# MONUMENT SMALL ENGINE STORAGE AMENDED SITE DEVELOPMENT PLAN

WITHIN A PART OF THE NORTHEAST QUARTER, SECTION 15,  
TOWNSHIP 11 SOUTH, RANGE 67 WEST OF THE 6th P.M.  
COUNTY OF EL PASO, STATE OF COLORADO

INDEX  
S1 Site Plan  
A1 Floor Plans  
A2 Elevations

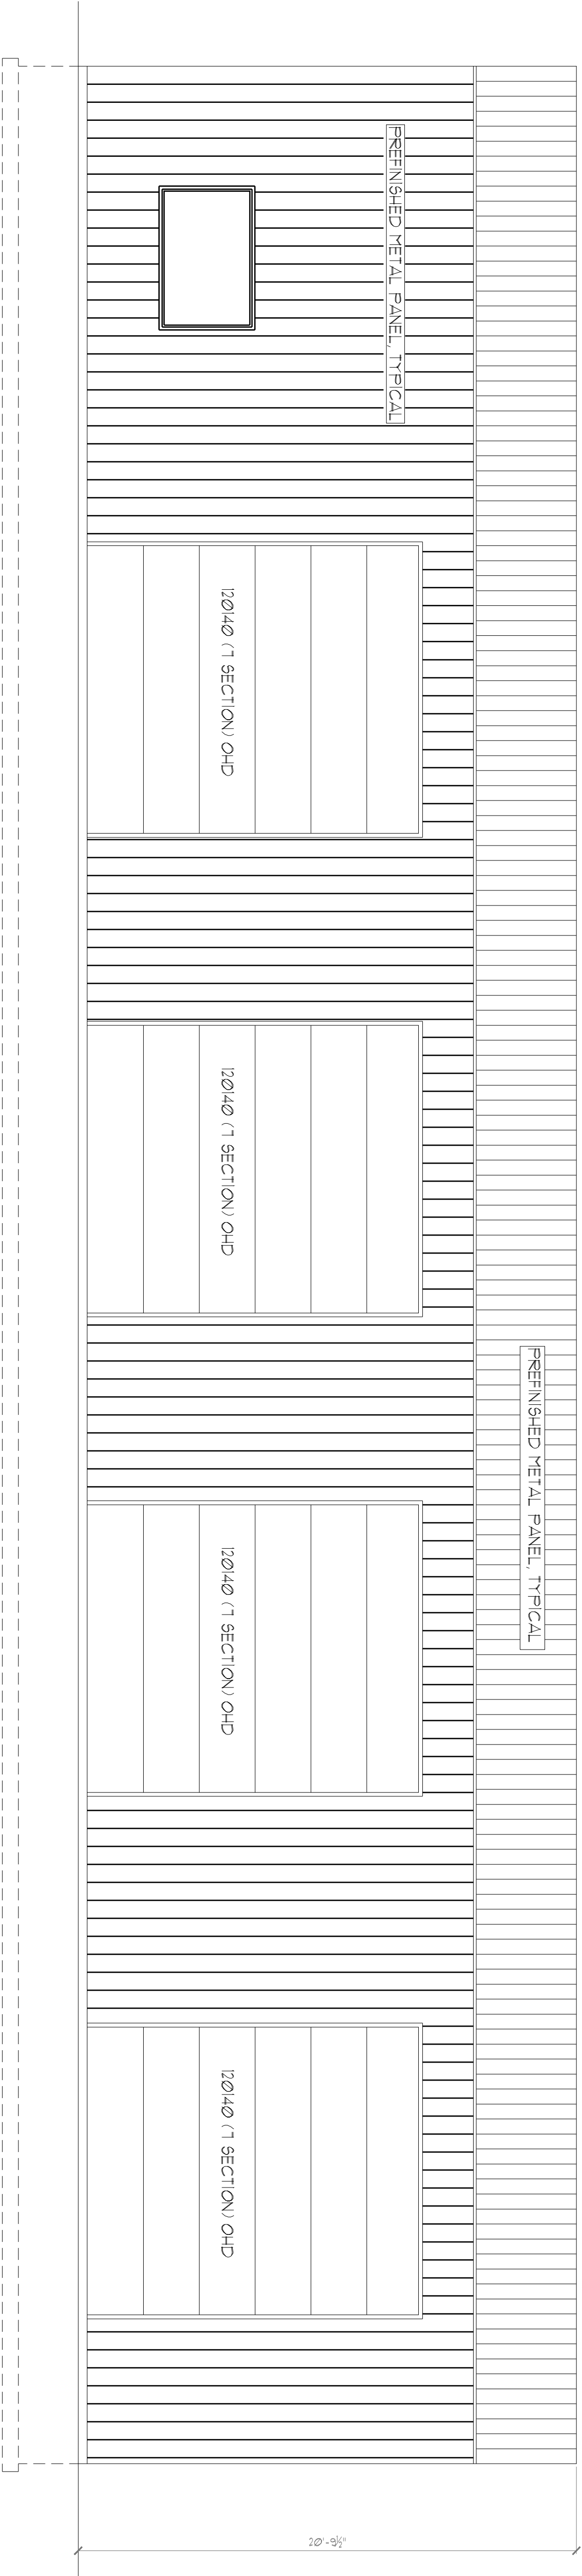
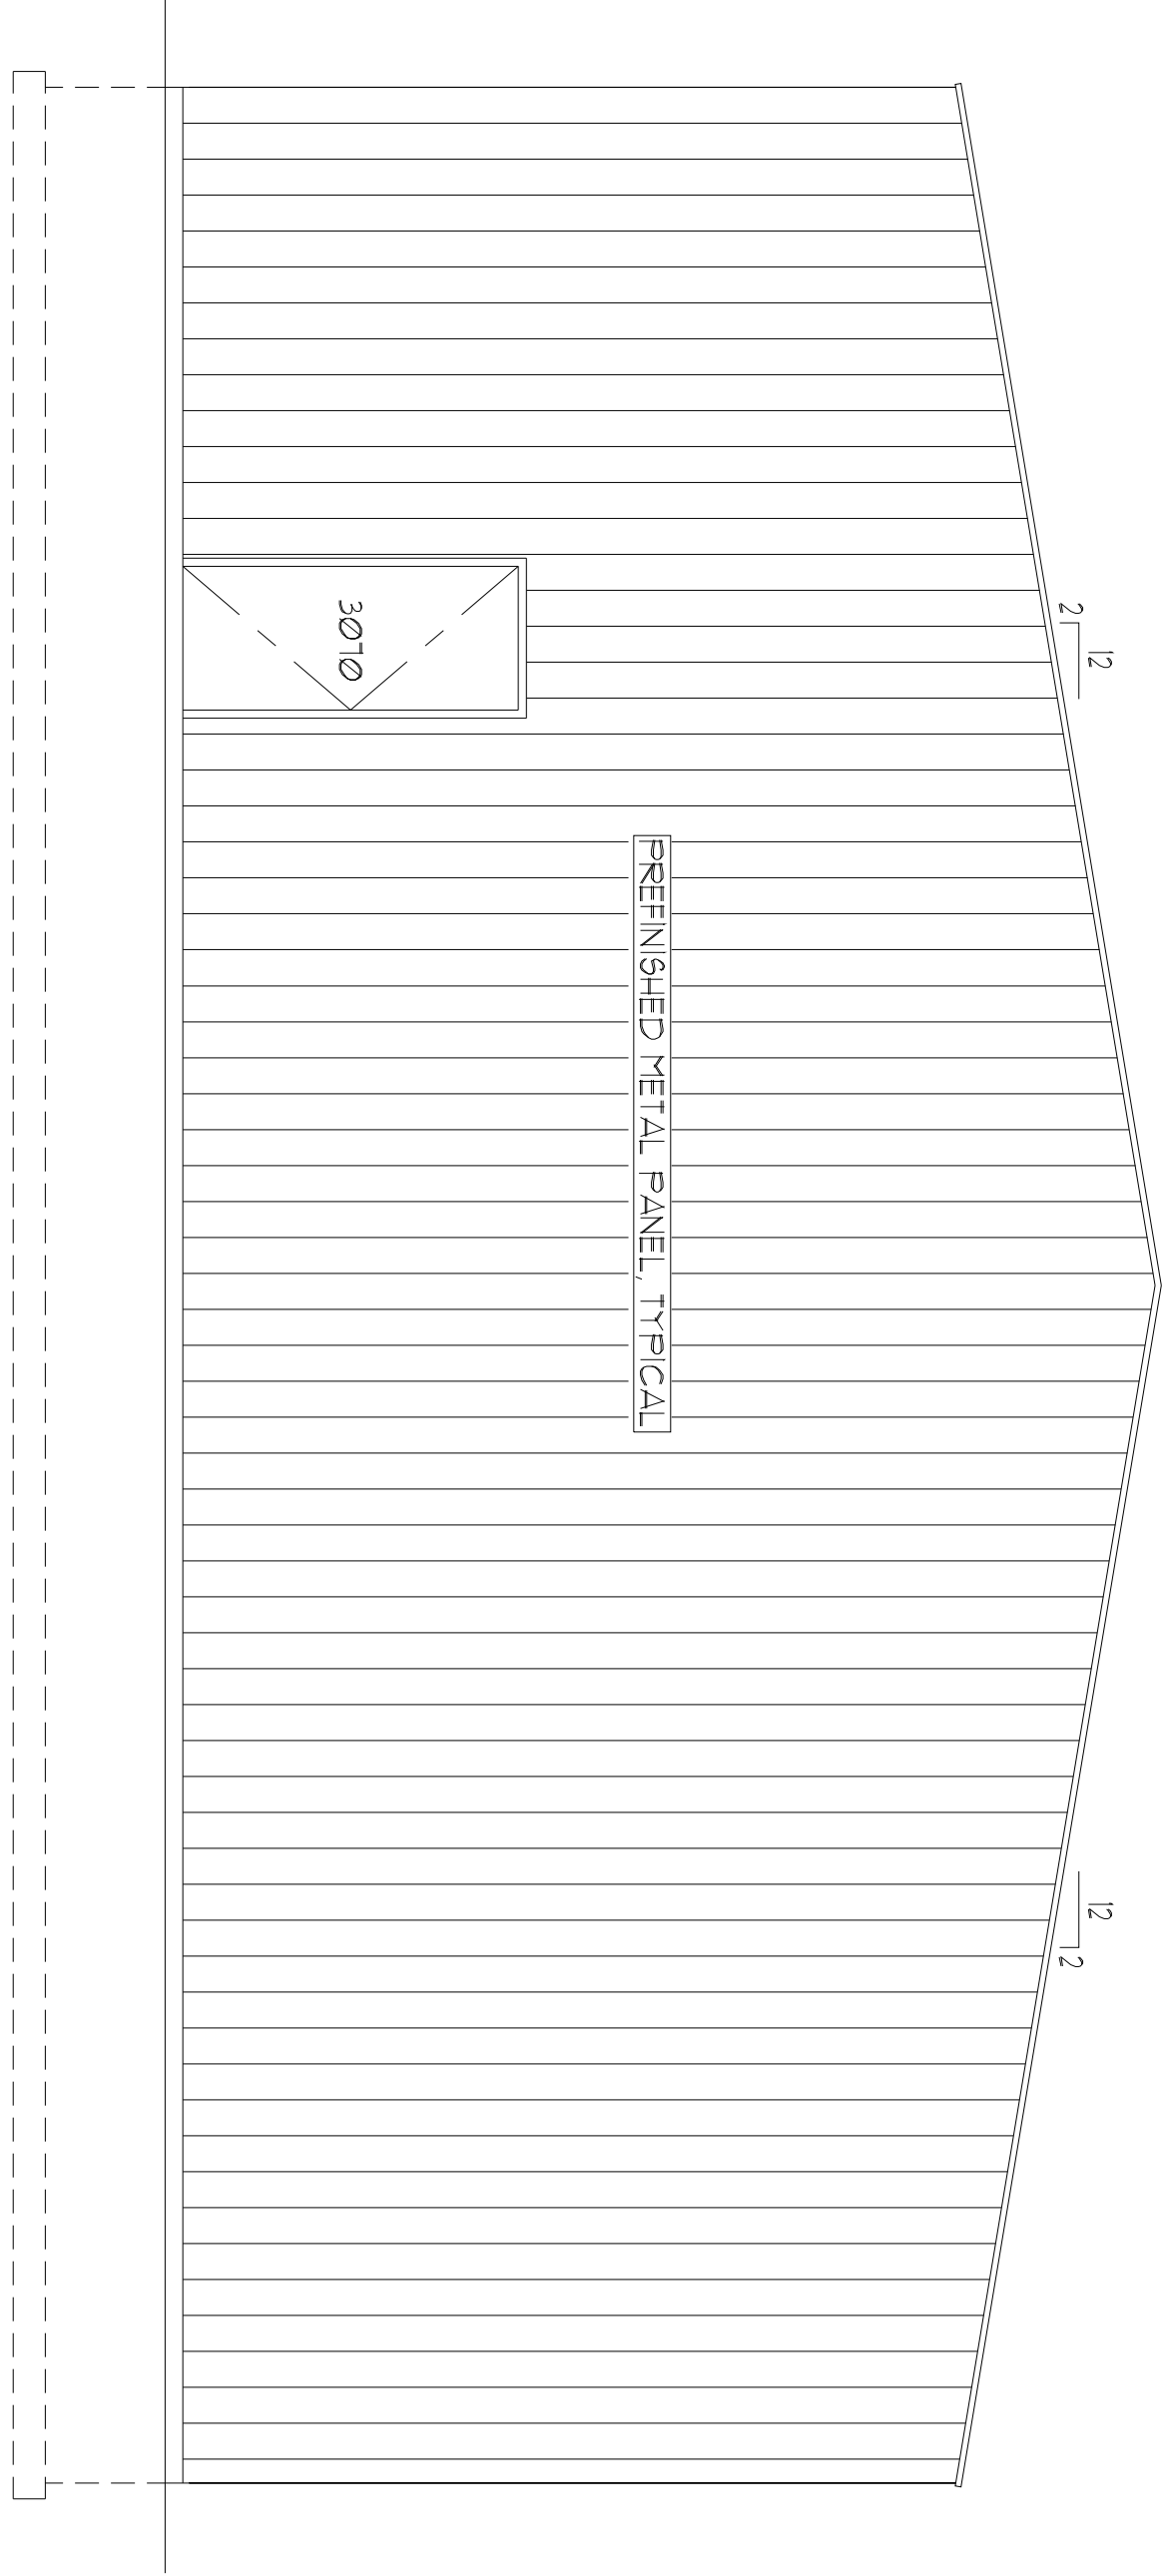
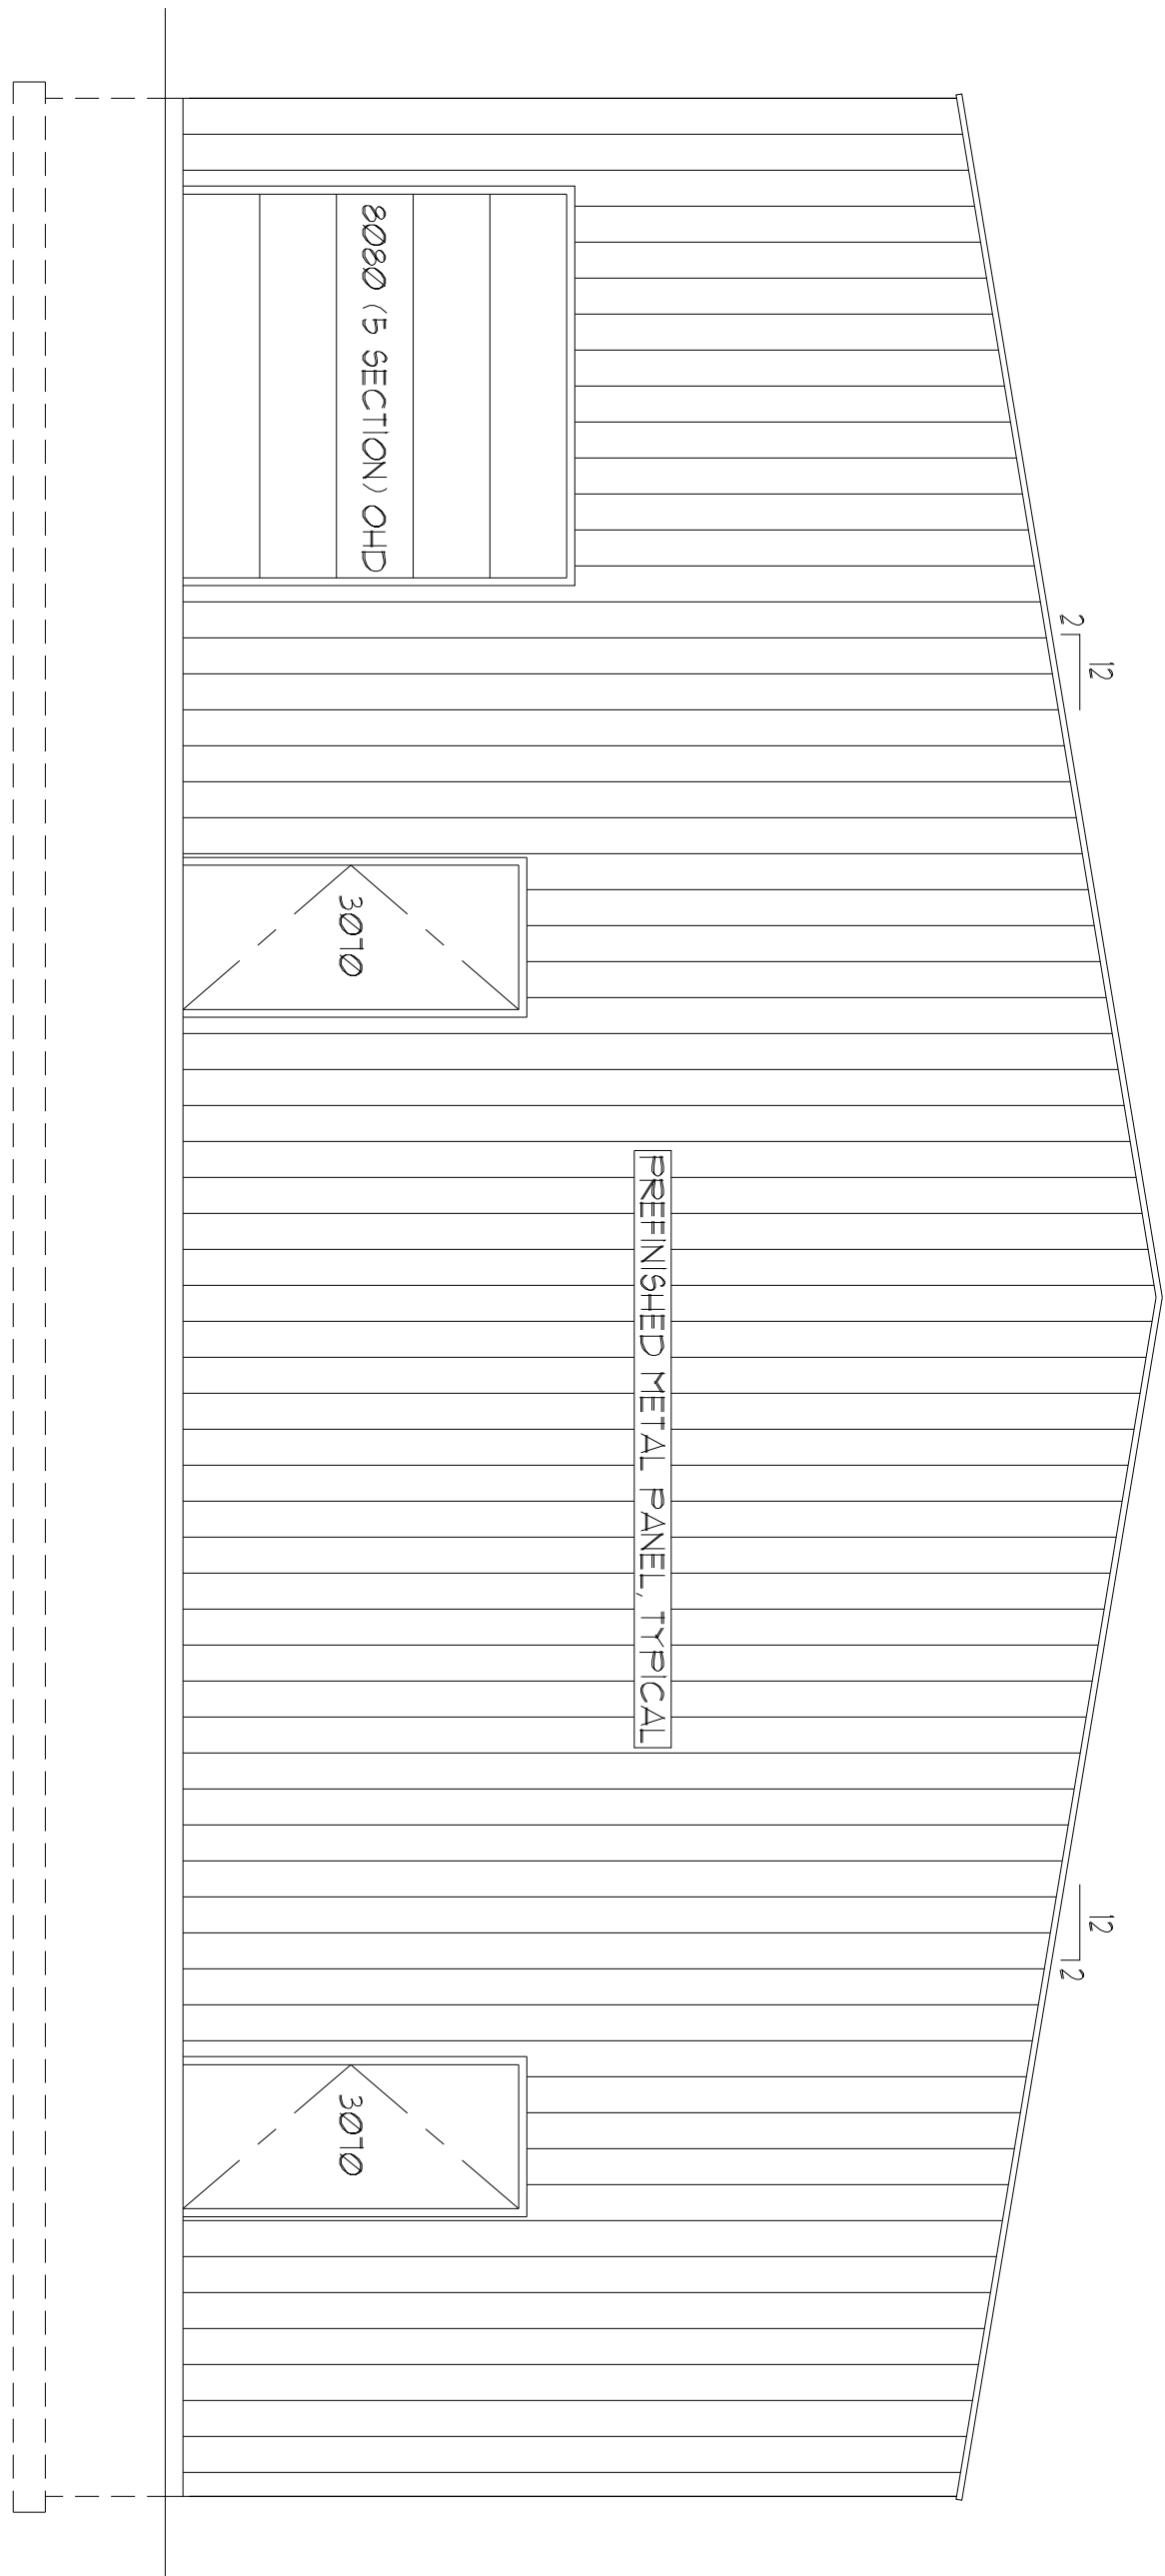
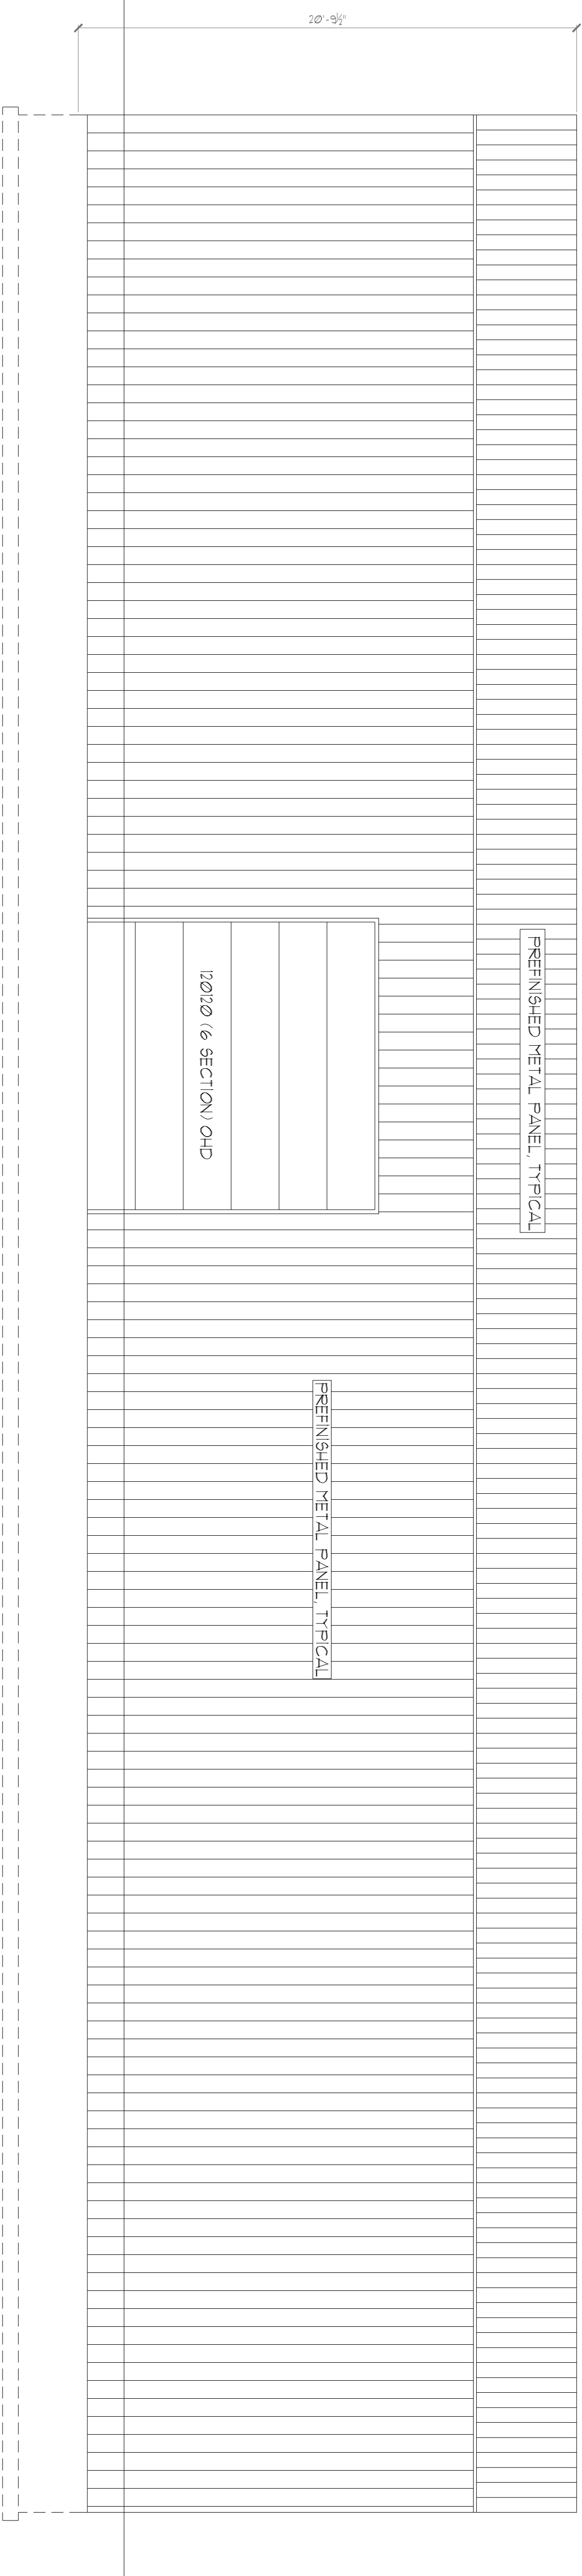
Please include parking detail showing dimensions of parking stalls and parking calculations. This plan does not use islands correctly nor does it have them landscaped. The parking lot configuration will not be approved as is. Please revise for safety and to meet the standards above. Using EDARP to review previously approved projects may be useful. PPR-20-002 is a good example of a properly planned parking lot.

Some of the larger discrepancies have been outlined but review full chapter 6 development guidelines for a full submission

Please include all building setbacks and dimensions. (Building D) A - GARAGE TO BE REMOVED B - SHED TO BE REMOVED C - SHED TO BE REMOVED D - GARAGE TO REMAIN
